**Planning and Urban Development Department
Planning Division**

RE: Comments for Proposed Development – Level III Review

Project:	Building Conversion	Project ID:	2018-011
Project Address:	415 Cumberland Ave.	CBL:	36-G-33
Applicant:	Sam Reiche		
Planner:	Christian Roadman

EXISTING WINDOWS TO BE REFURBISHED WHERE POSSIBLE, AND WHERE NECESSARY TO BE REPLACED WITH NEW WINDOWS TO MATCH EXISTING (NEW WINDOWS WILL BE DOUBLE GLAZED BUT WILL MATCH IN APPEARANCE)

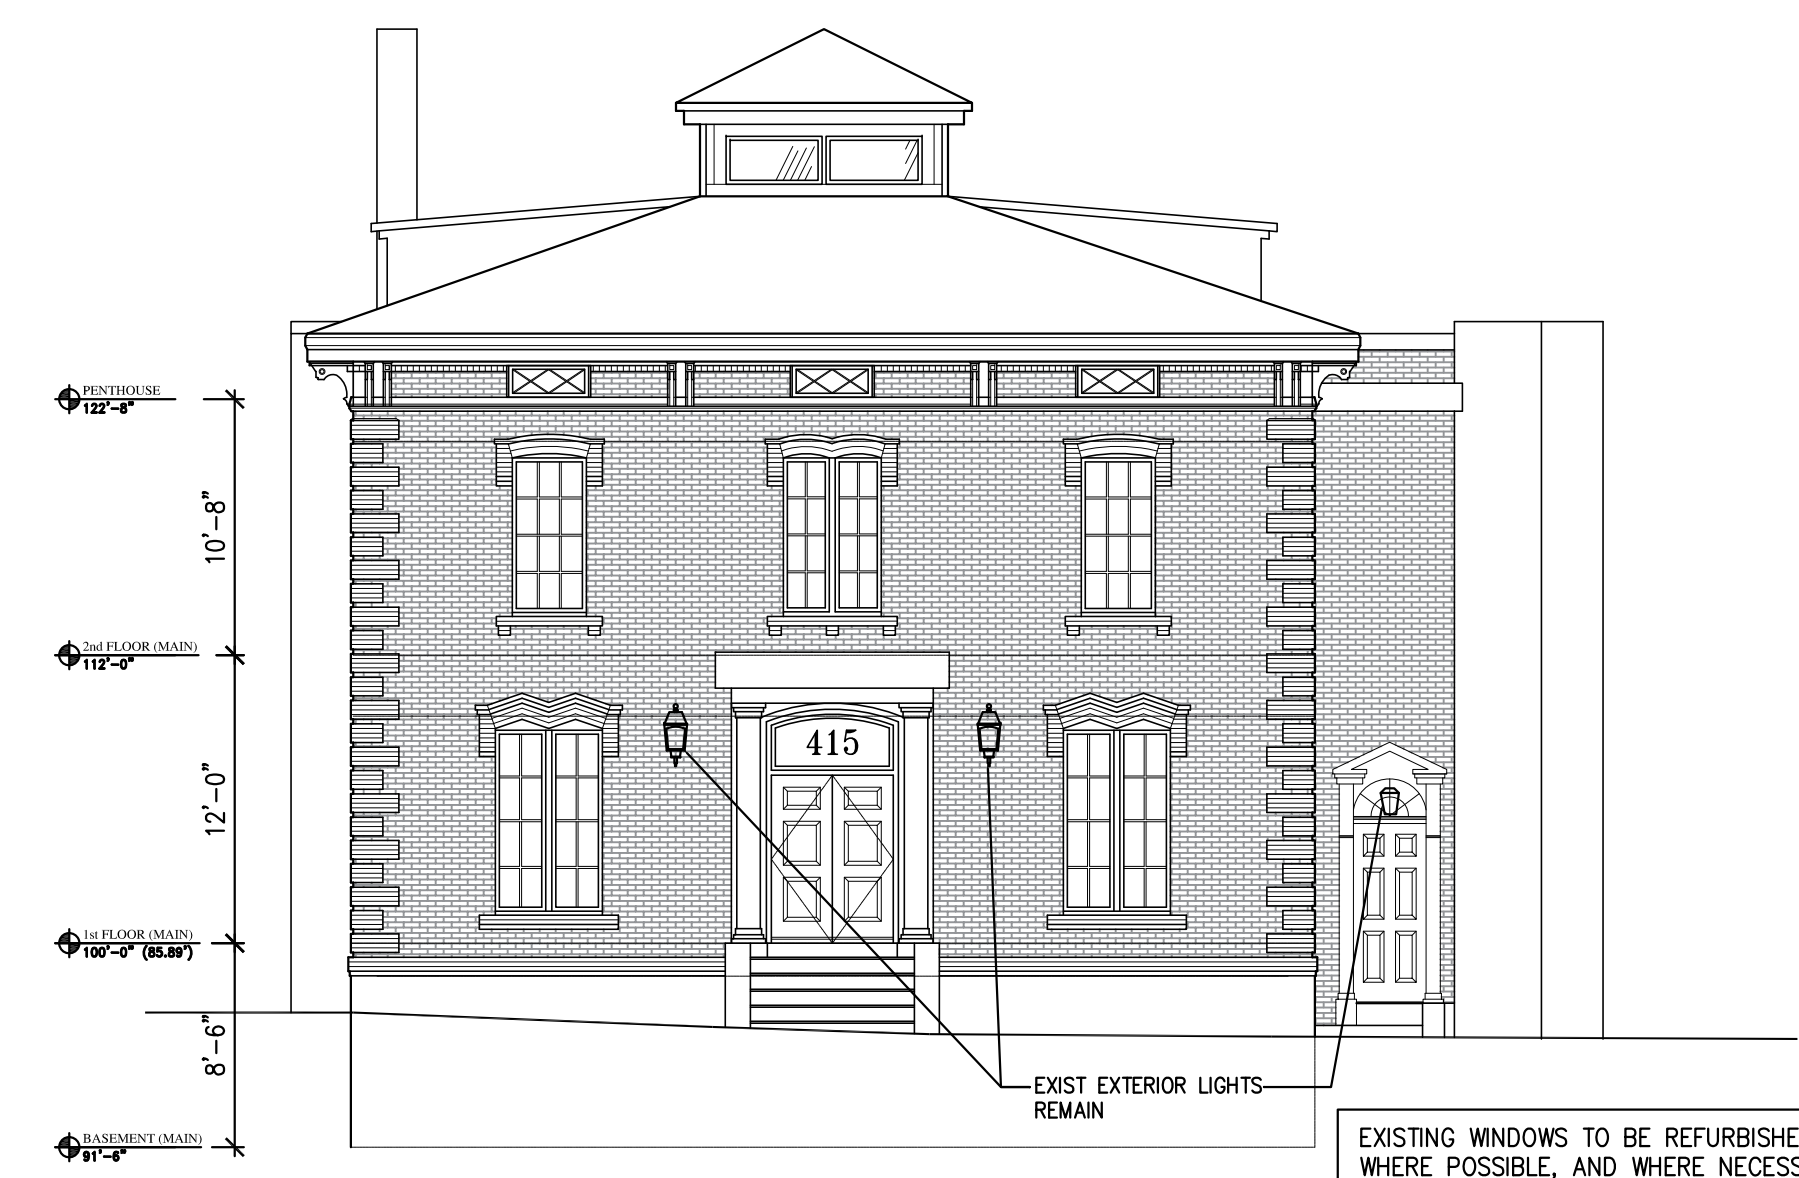
11. Please provide details on new windows. What are the materials? Windows should feature simulated divided lites with applied exterior muntins, at a minimum. Also, please identify which windows will be repaired and which will be replaced.

12. Please provide details regarding window moldings: will brick moldings be replicated in aluminum trim on other, new windows?
13. Why are two windows on the northwest elevation a different height than all other windows on that elevation and the Forest Avenue elevation? Ideally these will all match.

15. Please provide details regarding finishes. The painted finish of Hardie plank should not be high contrast, nor should the relationship of trim to the body of the building be high contrast.

16. Please specify the reveal / ttw of the Hardie plank. It should be less than 6.”
17. Hardie plank shall be installed smooth side out. Please note this on plans.

18. Exhaust vents shall be painted to match the surrounding material (brick or Hardie plank siding). Please note this on plans.
19. Hardie plank at the top of the building parapets on the Forest Avenue and southwest elevations seems strange – the treatments / bands along the top of the building’s middle section should be continued.

20. Please identify if garage doors will be replaced. If so, materials and details must be specified.
21. Please provide details regarding the proposed new door on Forest Avenue, especially regarding material and panelization.

22. The coal chute on the Forest Avenue elevation shall be retained, not removed or covered. Please show this on plans.

**1 OF 1**  
SHEET NUMBER

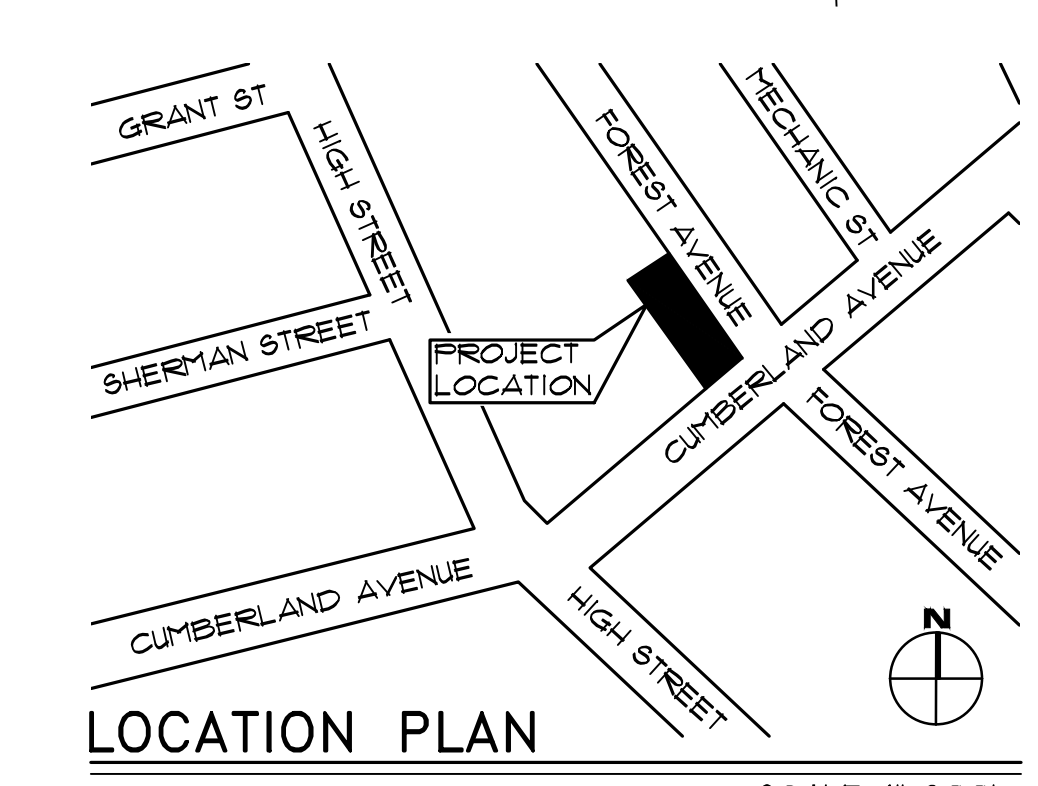
23. The existing ADA ramp at the corner is shown in an odd way – the curb line should be drawn to show the location of the ramp tactile warning strip.
24. The plat shows the ROW line on Cumberland crossing features out of the sidewalk (bottom step and the mulch planter areas). That may be the existing condition, but also may need to be addressed on the plat.

**C1.2**

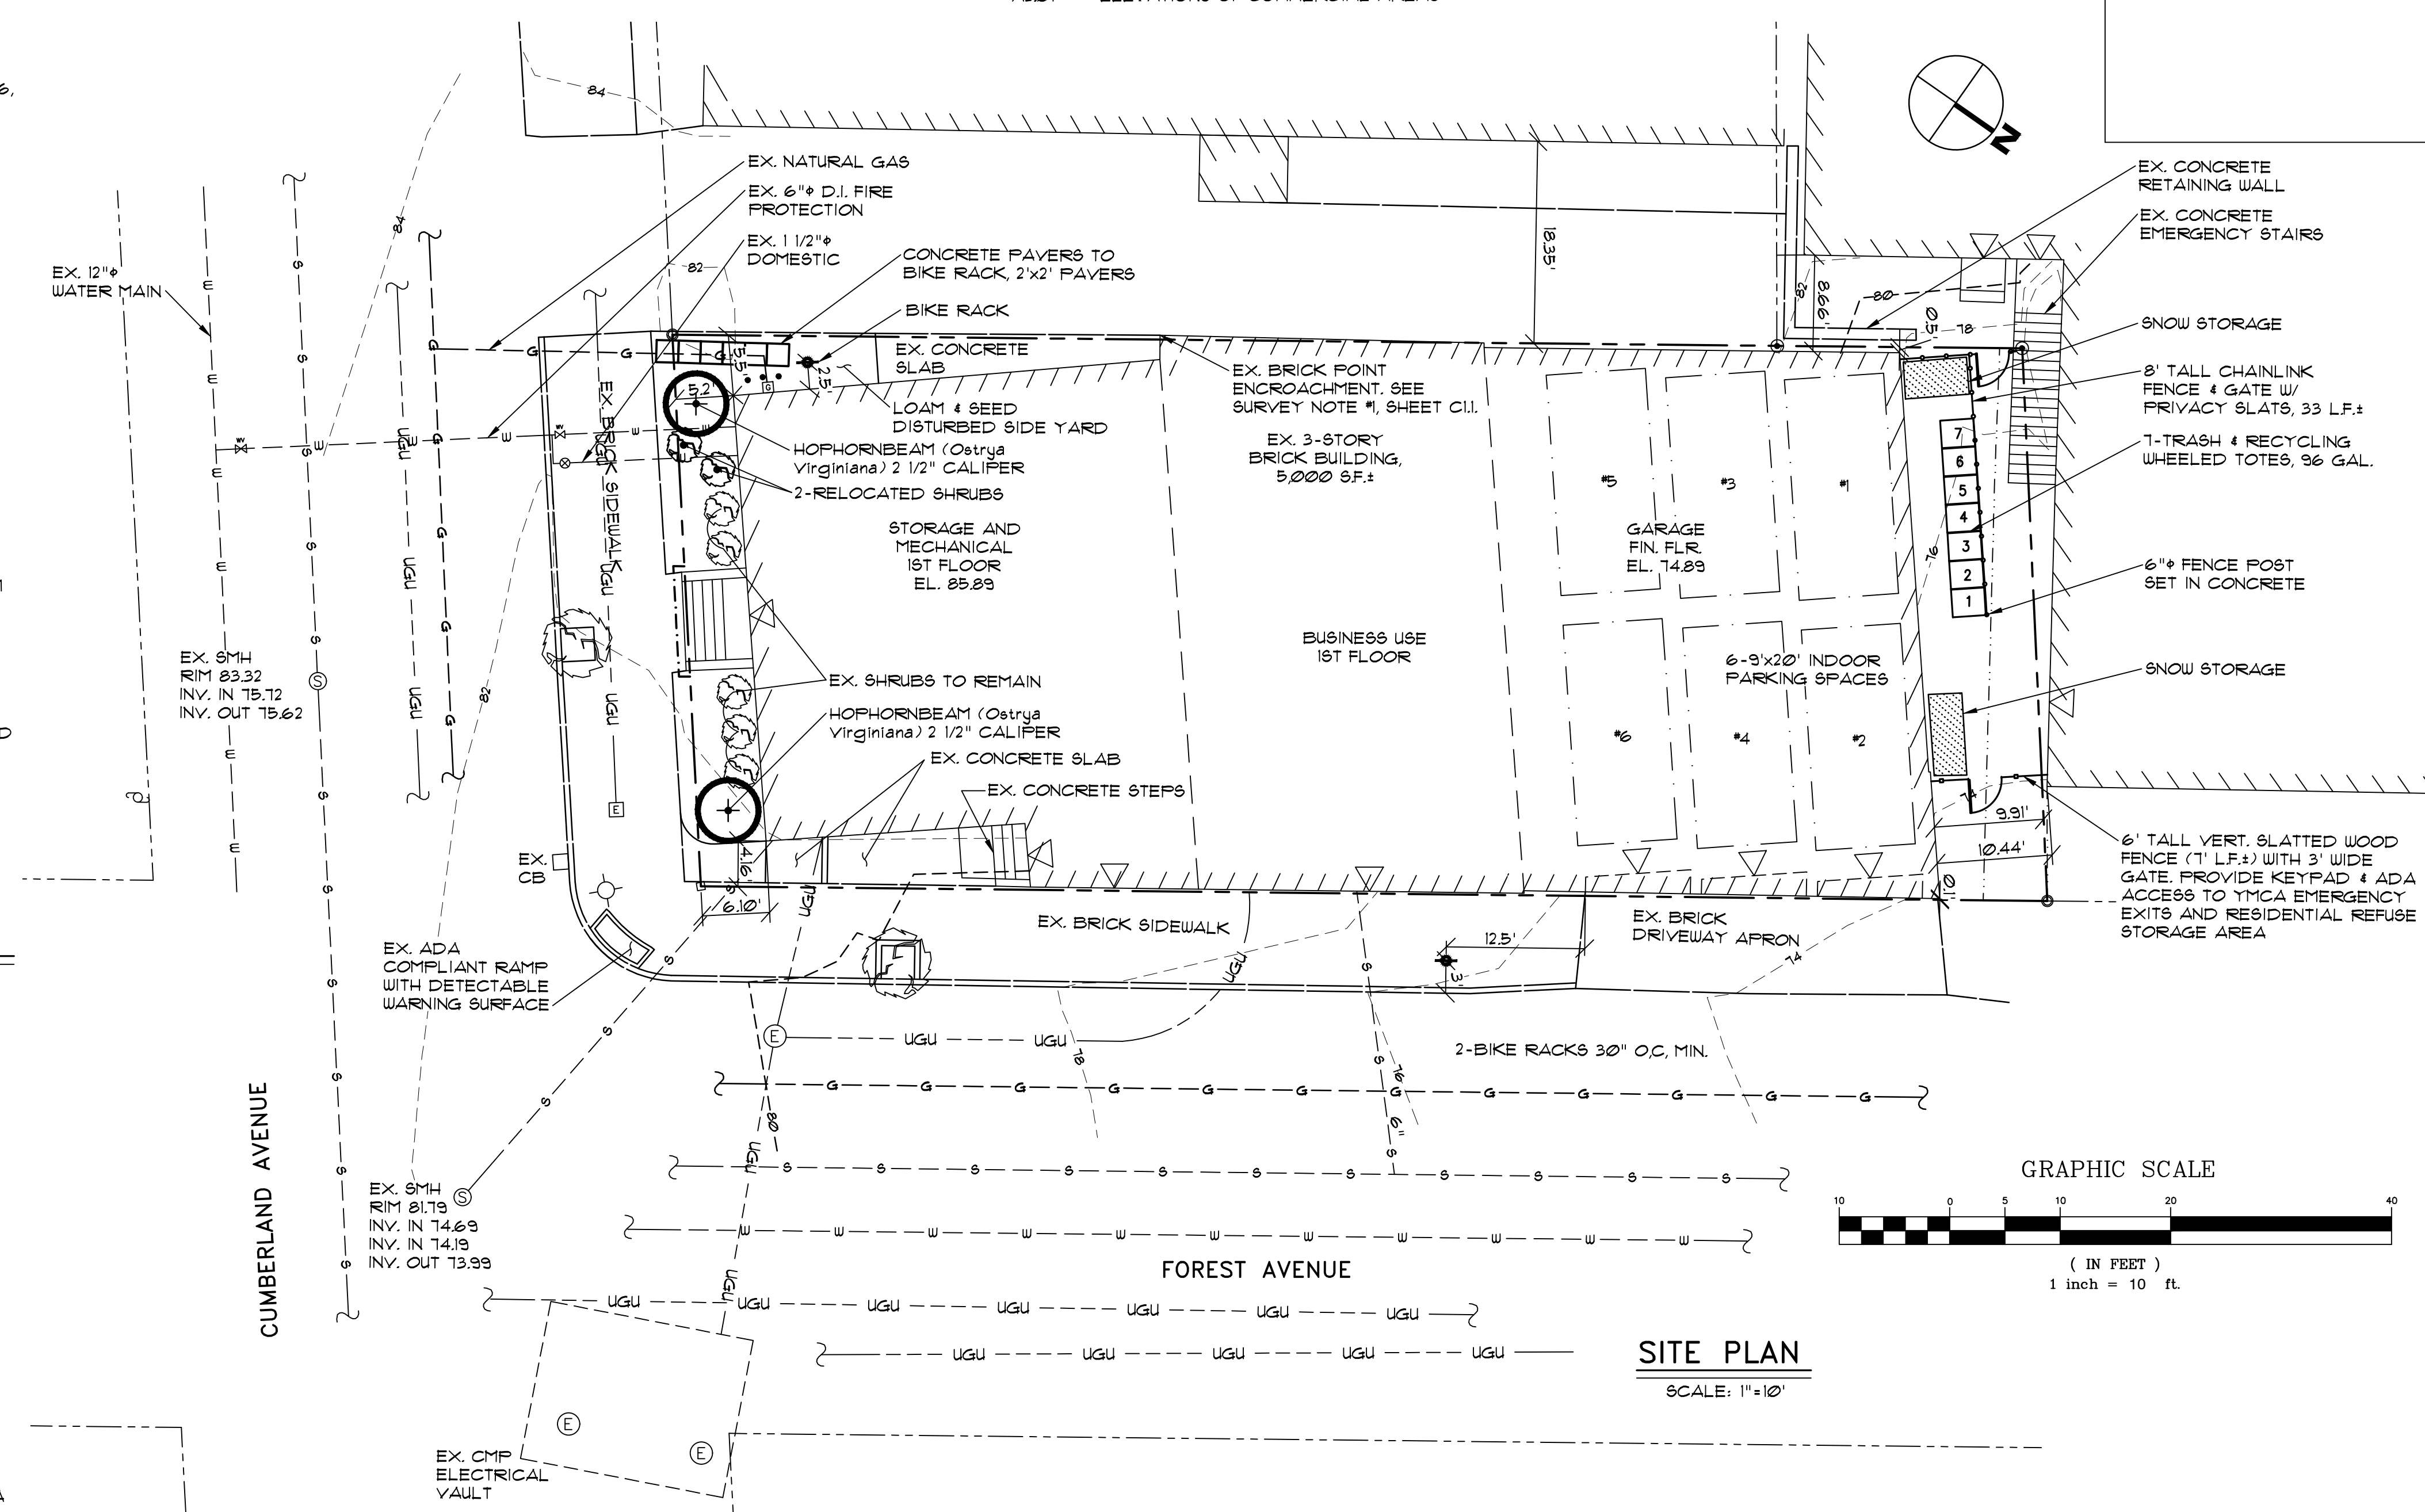
2. The content of the landscaping plan uploaded in January does not match the landscaping identified on the Site Plan uploaded in March. Please revise and ensure consistency between the two documents.

5. Please provide cut sheets of exterior lighting fixtures.
6. The provided survey includes half the interior parking spaces detailed on the site plan. Please ensure consistency between documents and revise.

9. The layout and dimensions for the two bicycle racks need to be checked for adequacy. The minimum clearance (O.C.) are: from the building, 30"; between racks, 36"; and from the edge of the driveway, 24." Sufficient clearance from the exterior gas service and bollards also must be considered. It appears the bike racks would also block access to the external stairway from the second floor without going onto the adjacent property. Other bicycle rack locations on-site or within the sidewalk on either Forest and / or Cumberland Avenue can also be considered to make them more functional and not block this access.

10. The ADA compliance of the driveway, including that section of sidewalk, on Forest Avenue should be confirmed for cross-slope (maximum 2% cross-slope for a minimum of 5' of width) and condition.
